APPLICATION NO: **A/114/18/PL**

Site Address: Broadlees Dappers Lane Angmering BN16 4EN

Description of Works: Demolition & erection of 70 bed care home within Use Class C2 (replacing building 4 approved by A/27/16/PL), access, parking, landscaping and other associated works

TO:	Arun District Council FAO: Michael Eastham
FROM:	Stephen Gee Highways, WSCC
DATE:	13/09/18
LOCATION:	Broadlees, Dappers Lane, Angmering, West Sussex, BN16 4EN
SUBJECT:	A/114/18/PL Demolition & erection of 70 bed care home within Use Class C2 (replacing building 4 approved by A/27/16/PL), access, parking, landscaping and other associated works.
DATE OF SITE VISIT:	
RECOMMENDATION:	☒ Advice ☐ Objection ☒ Modification ☐ No Objection ☐ More Information ☐ Refusal
S106 CONTRIBUTION TOTAL:	£ See below for breakdown.

Appendix E – Proposed Pedestrian Infrastructure

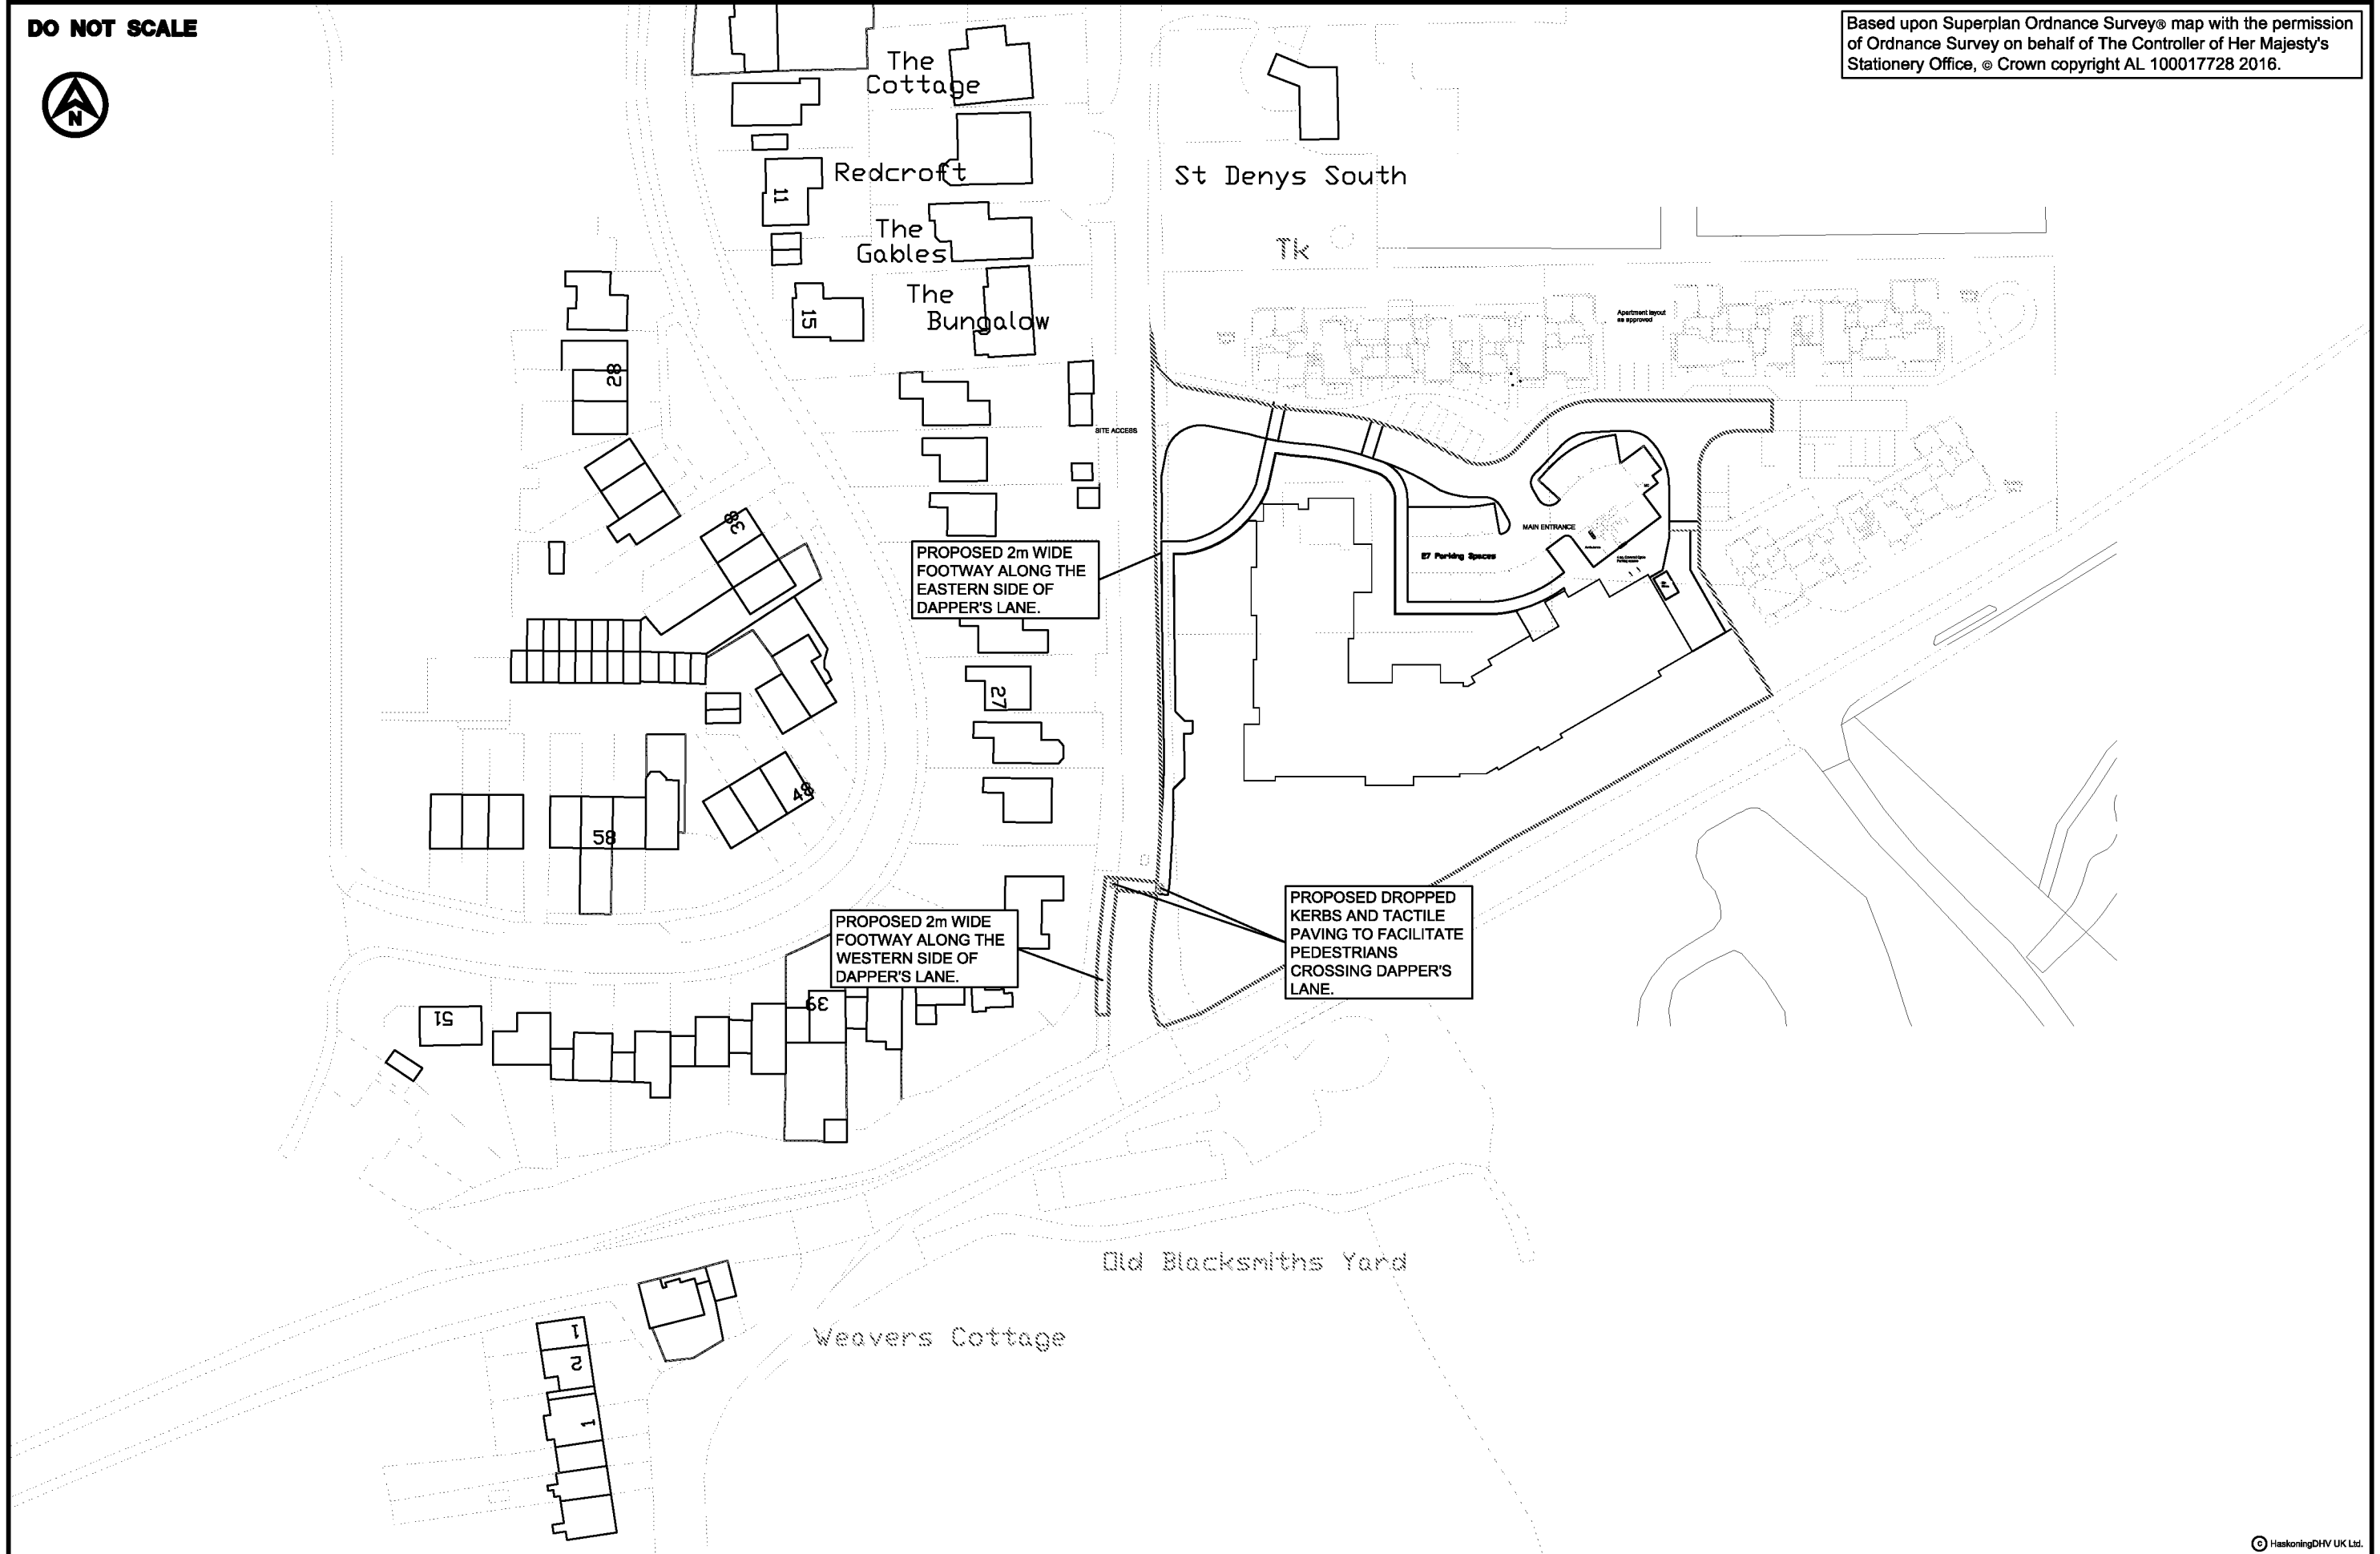
As part of the consented development the applicant is to provide a 2.0m footway from the site access south alongside the existing grass verge and informal pedestrian crossing with tactile paving, dropped kerbs before extending further south on the eastern side of the carriageway to meet the existing provision. (as shown on drawing PB7693-SK01)

It is recommended that the proposals are modified to include provision of a footway along the southern boundary of the site (both red and blue line boundary) and the travel plan is revised to incorporate the above comments.
